**The Stables College Farm Main Street  
Wendlebury Bicester OX25 2PR**

**24/00817/F**

**Proposal:** The change of use and conversion of equestrian stables and storage barn to a create a single residential dwelling

Proposed Internal Elevations

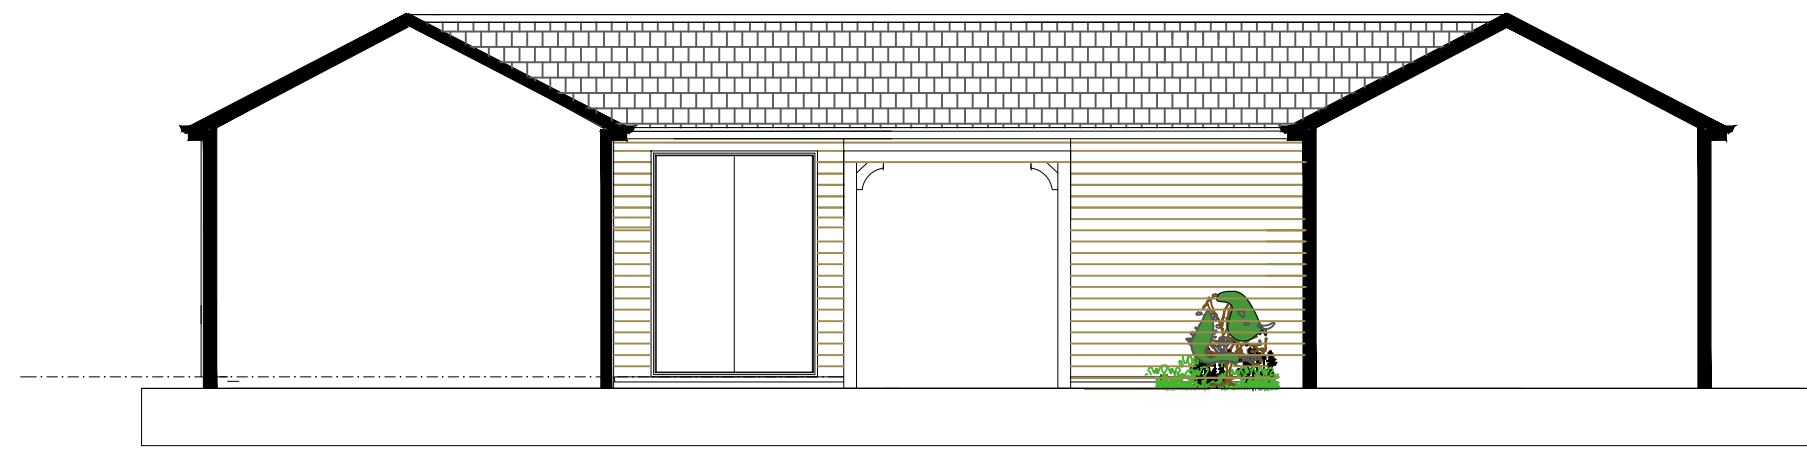
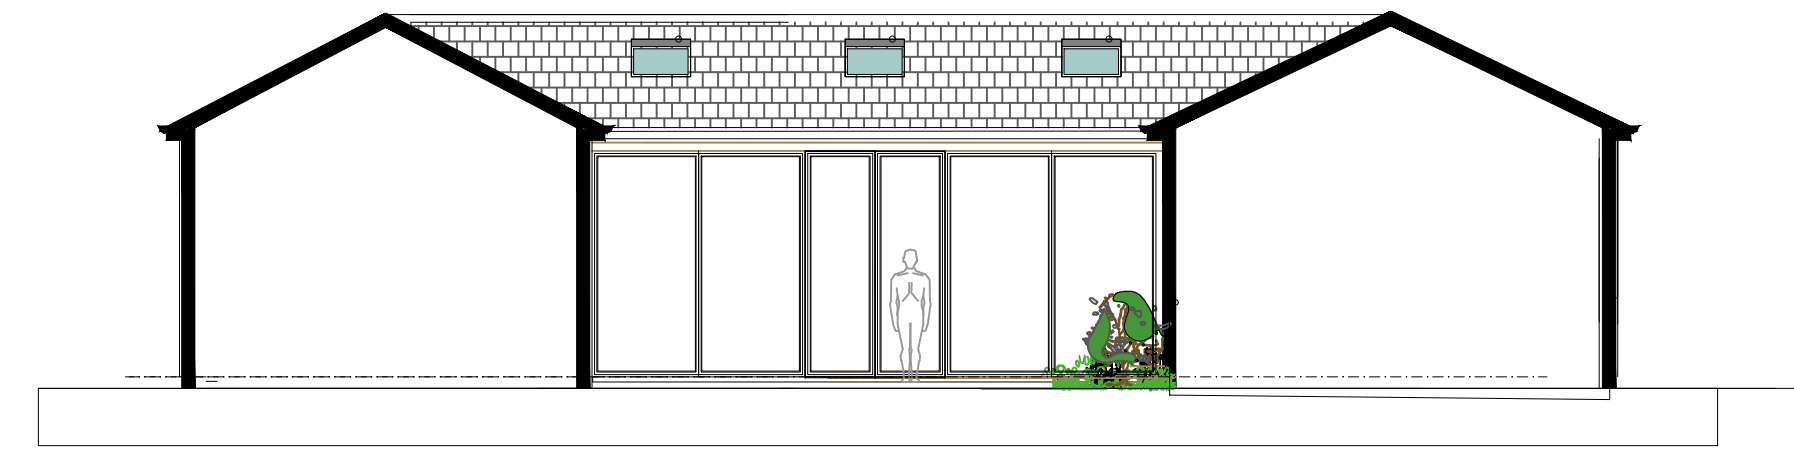
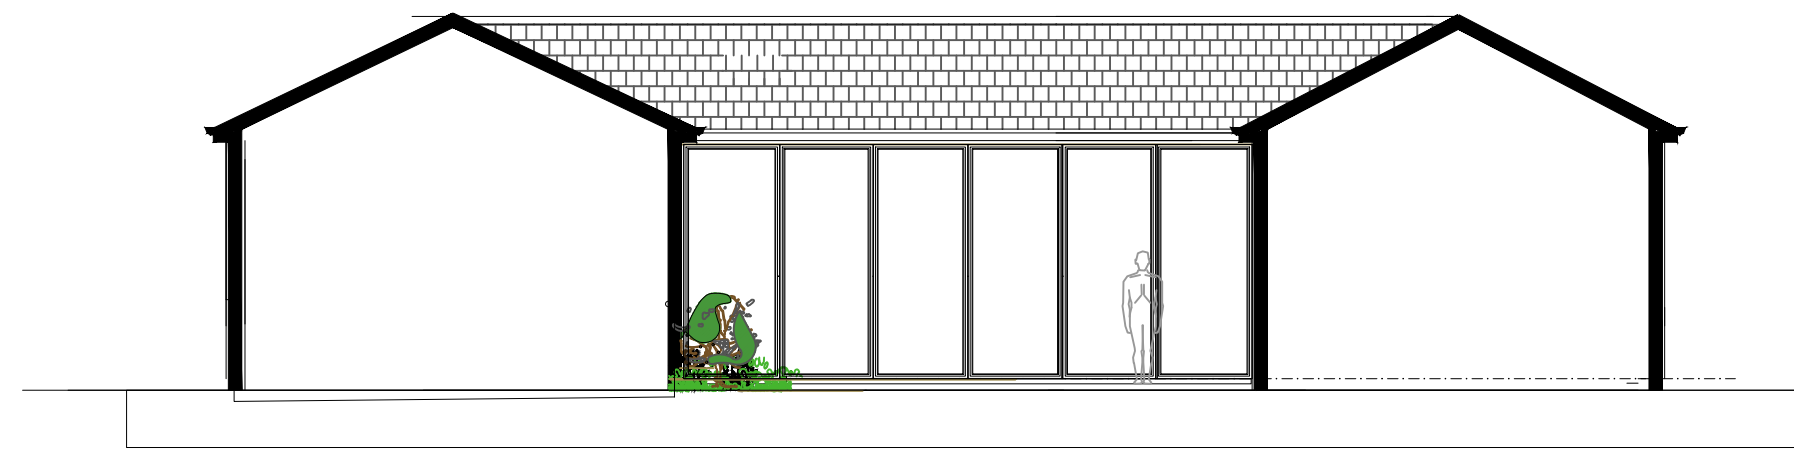
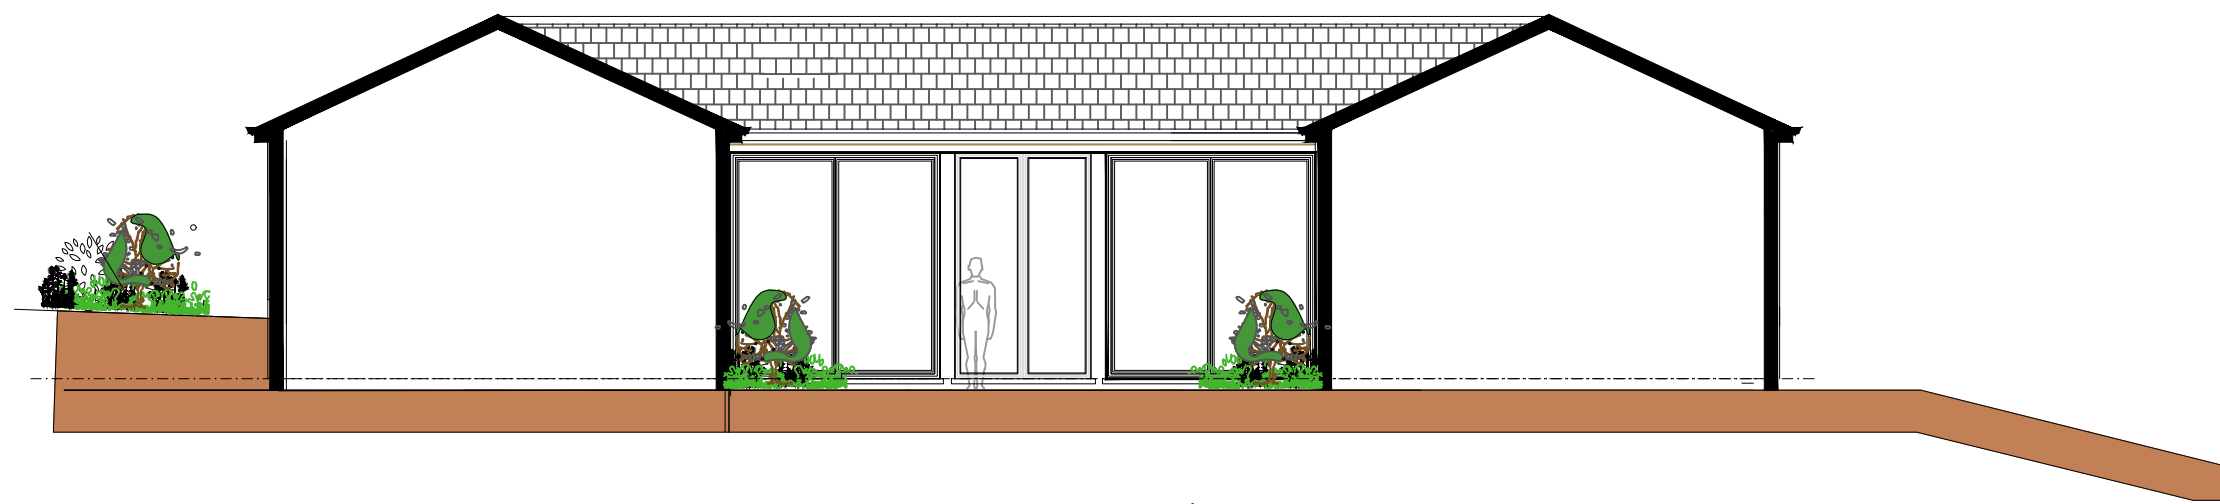
enclosure of the garage area with glazing and a garage door. An additional door would be added to the west elevation and amendments to the windows on the east elevation (including the addition of shutters to match existing). The internal courtyard would have additional glazing to all elevations.

- 8.7. Overall, the changes are considered to be in keeping with the design of the building. The external changes are minor and would not alter the overall character of the building. The glazing within the courtyard would not be visible from outside the site and provides the benefit of allowing natural light.

Proposed West Elevation

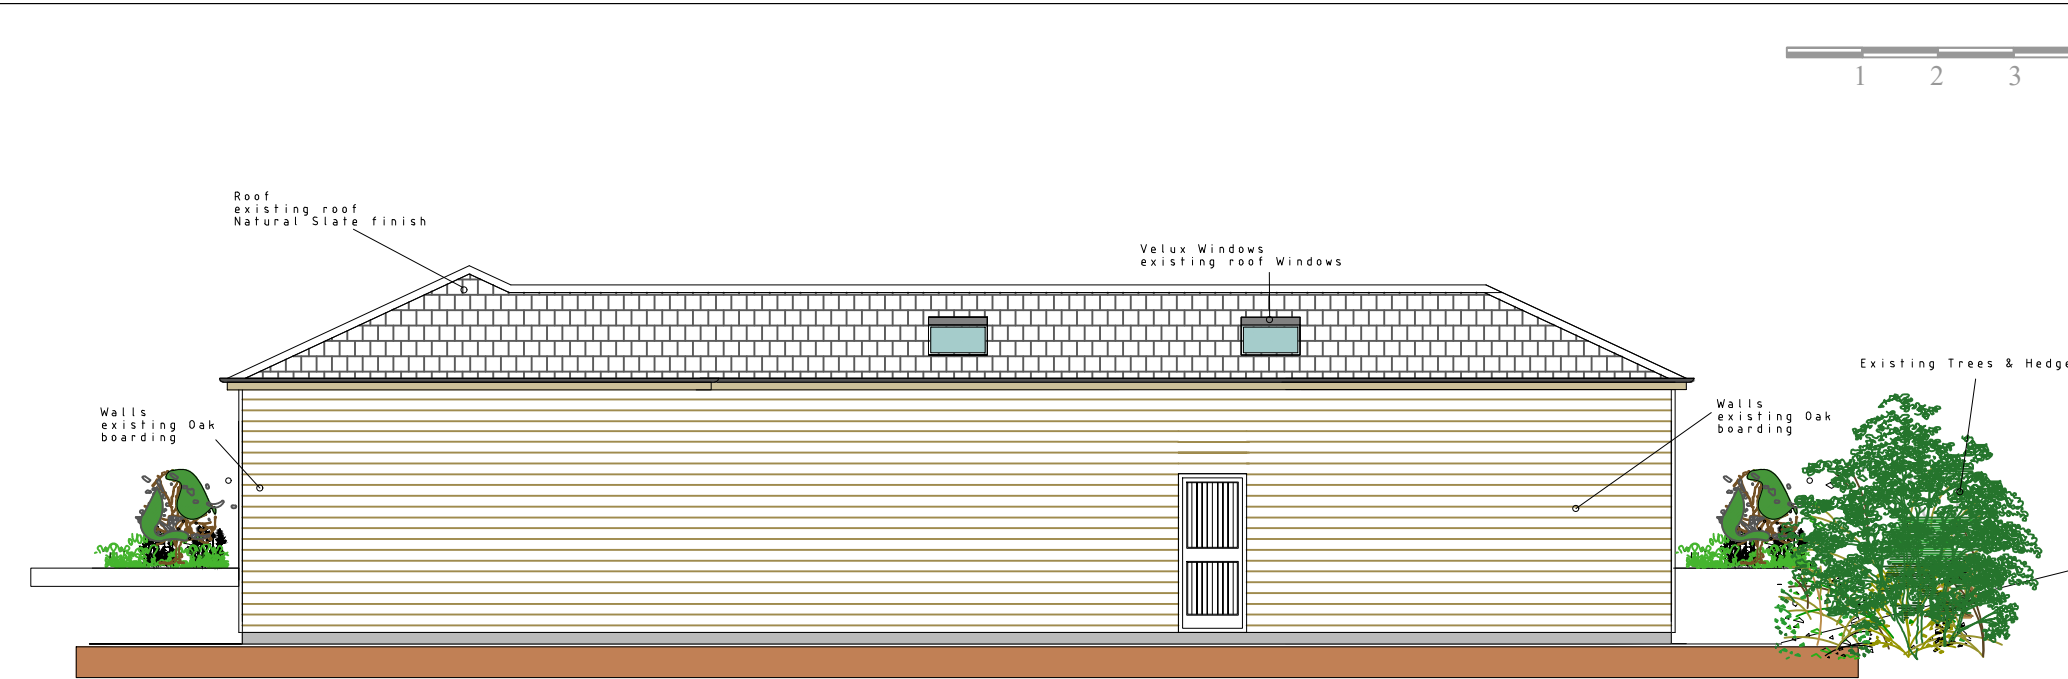
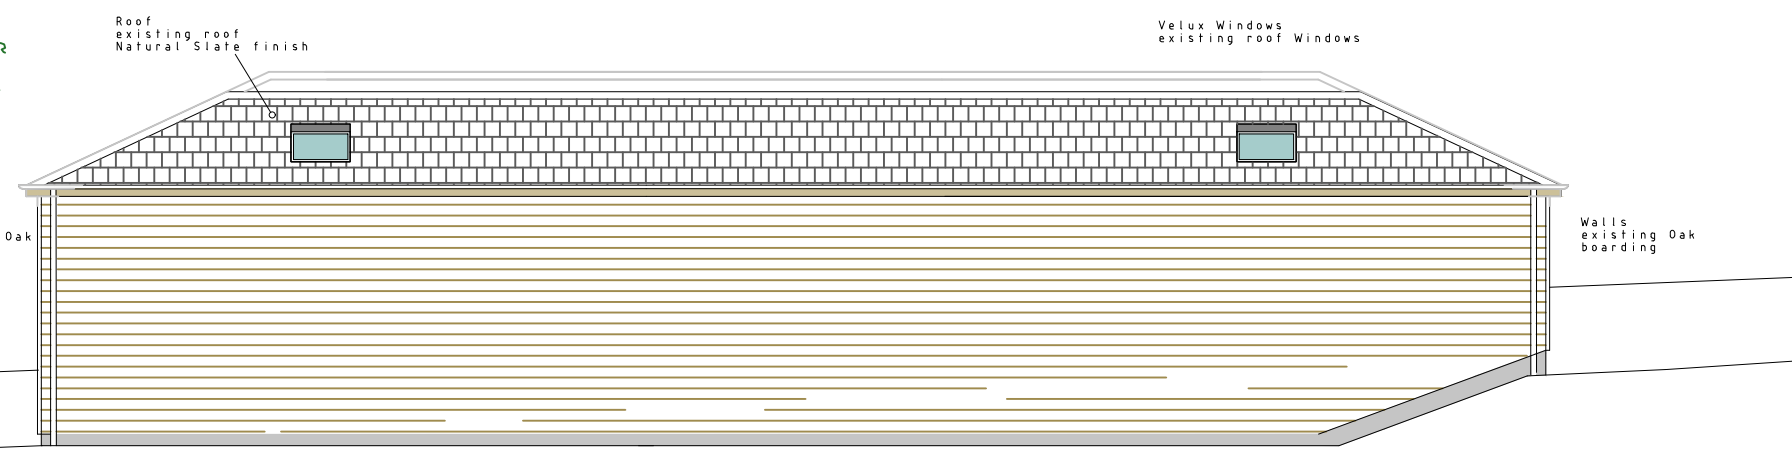
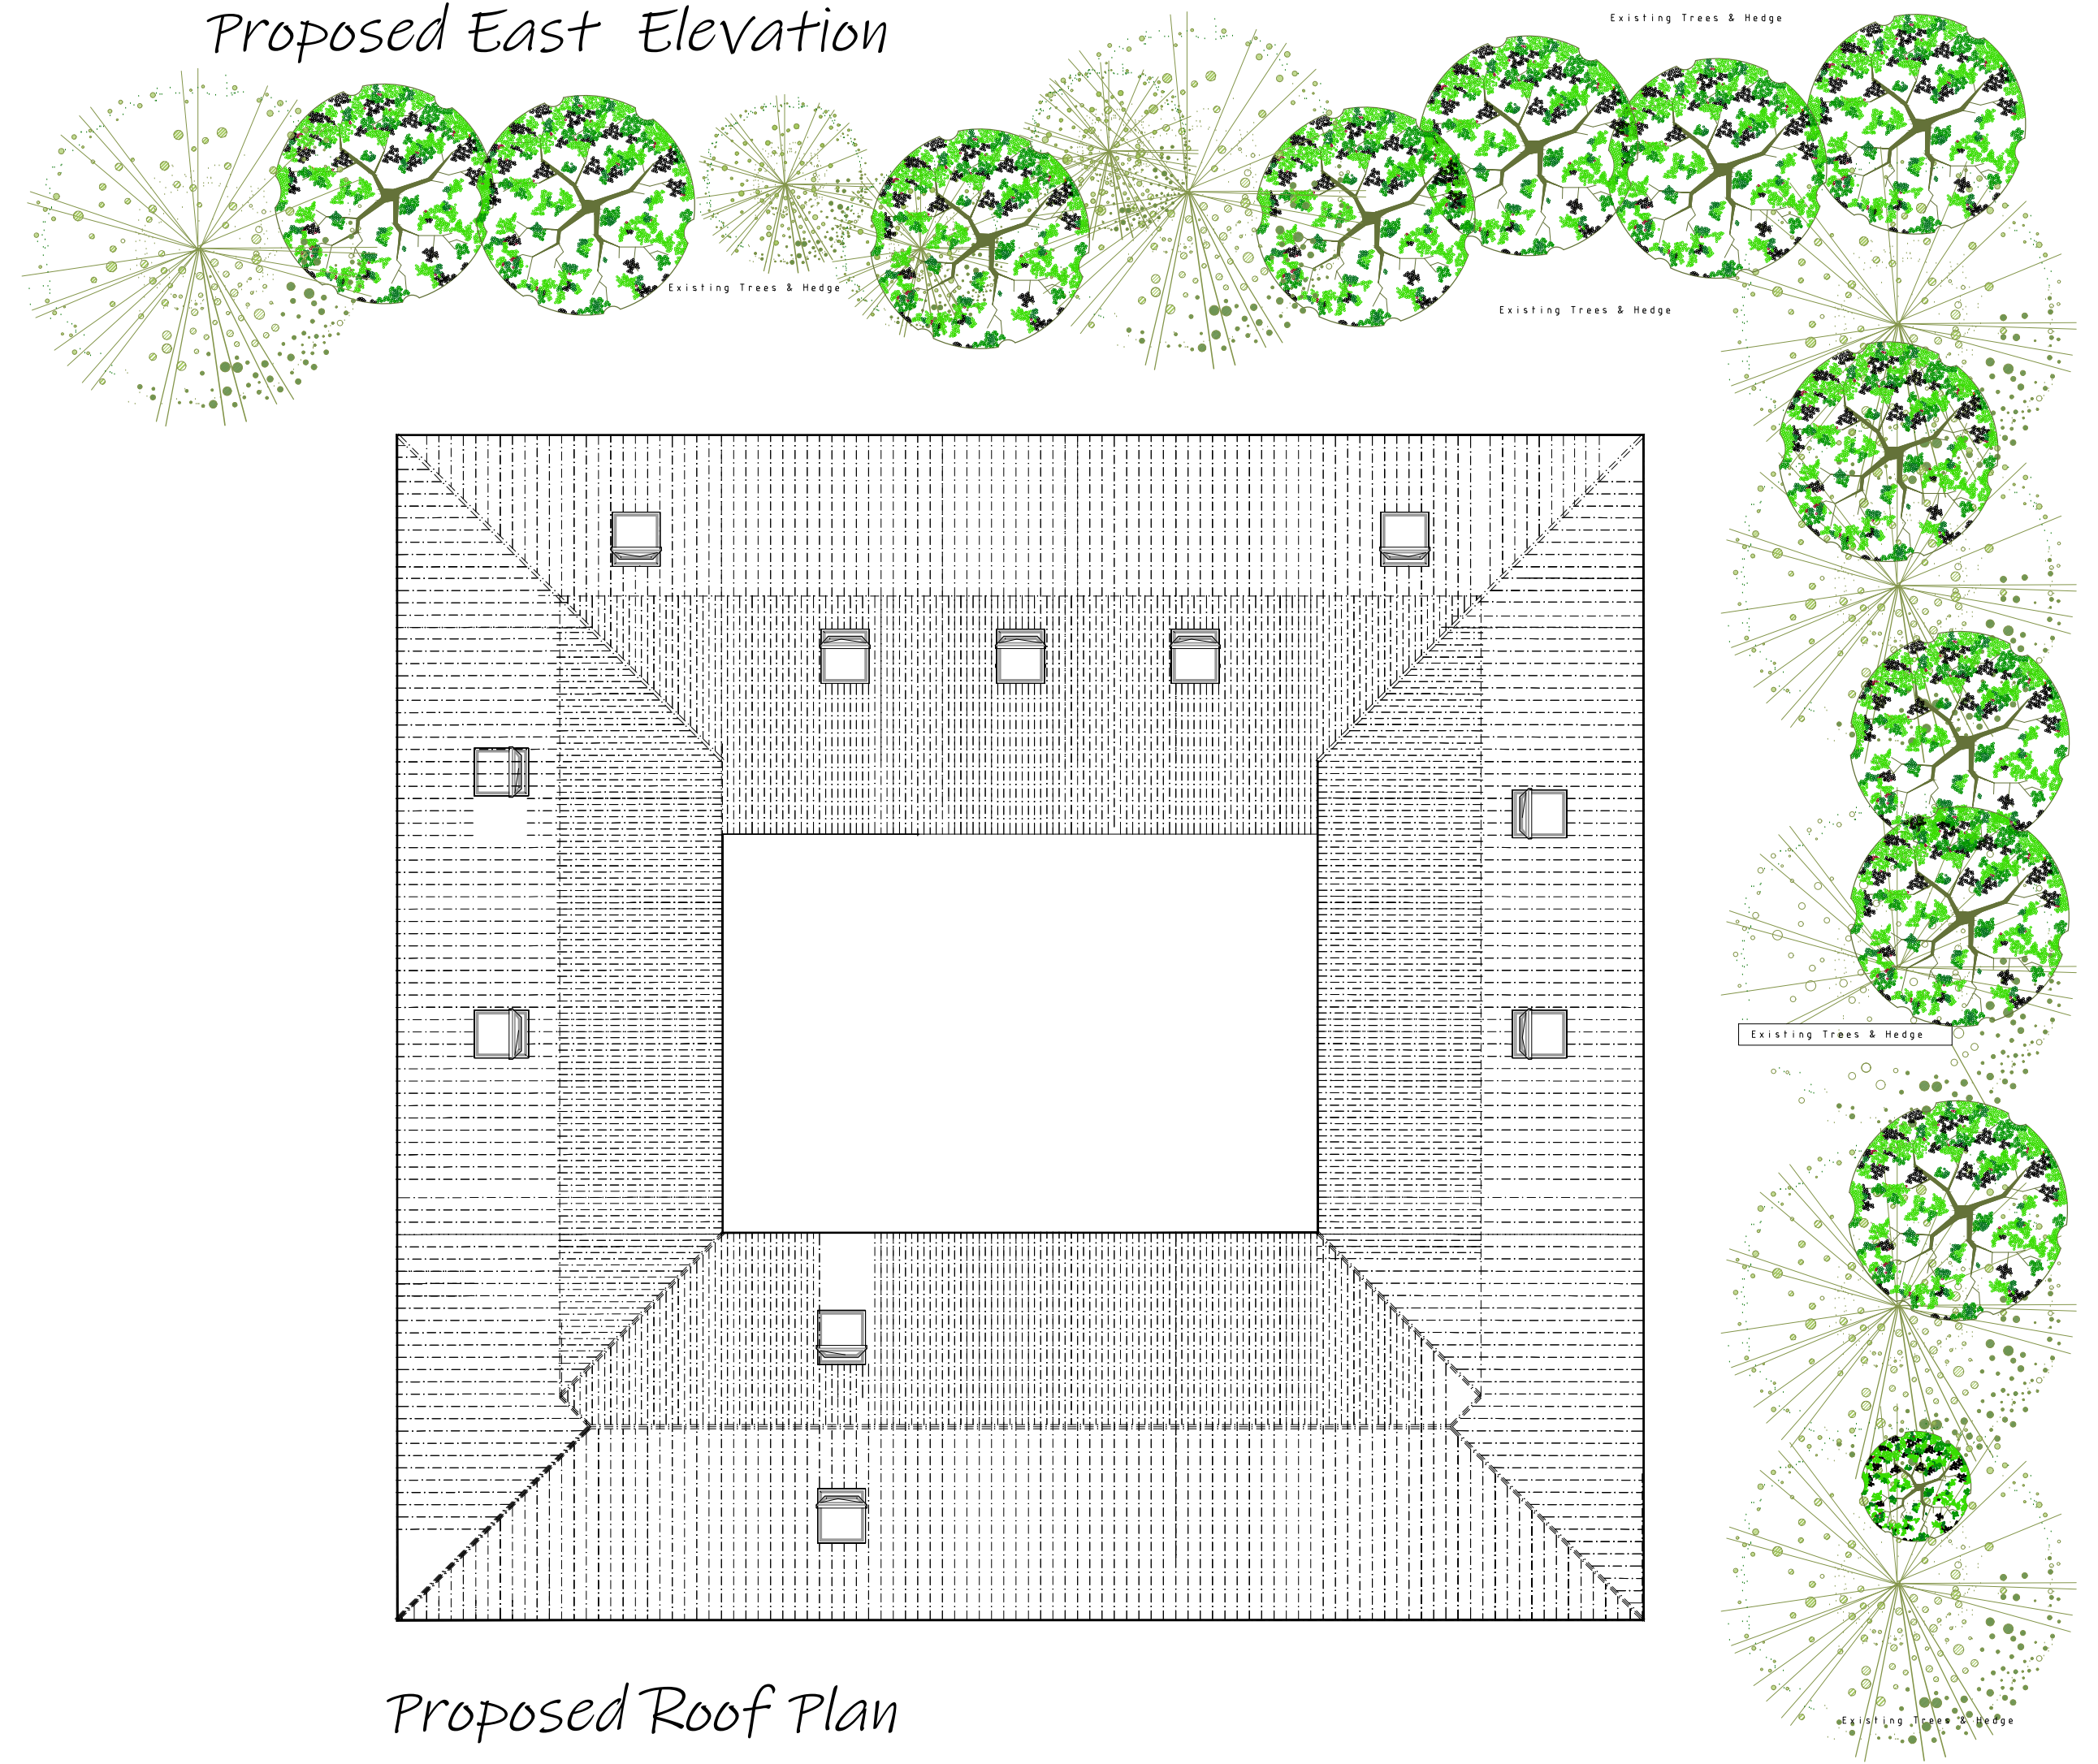
- 8.11. The west elevation (facing the neighbouring properties) contains no windows, so there is no direct overlooking. The proposals do show the addition of a door on the elevation, but a condition may reasonably be imposed to prevent this being a glazed door and, although someone could stand at the door to look into the gardens of the neighbours, this would be no different to standing by the fence and looking over.

3. The door in the west elevation of the building shall be a solid door and shall not include any glazing panels.
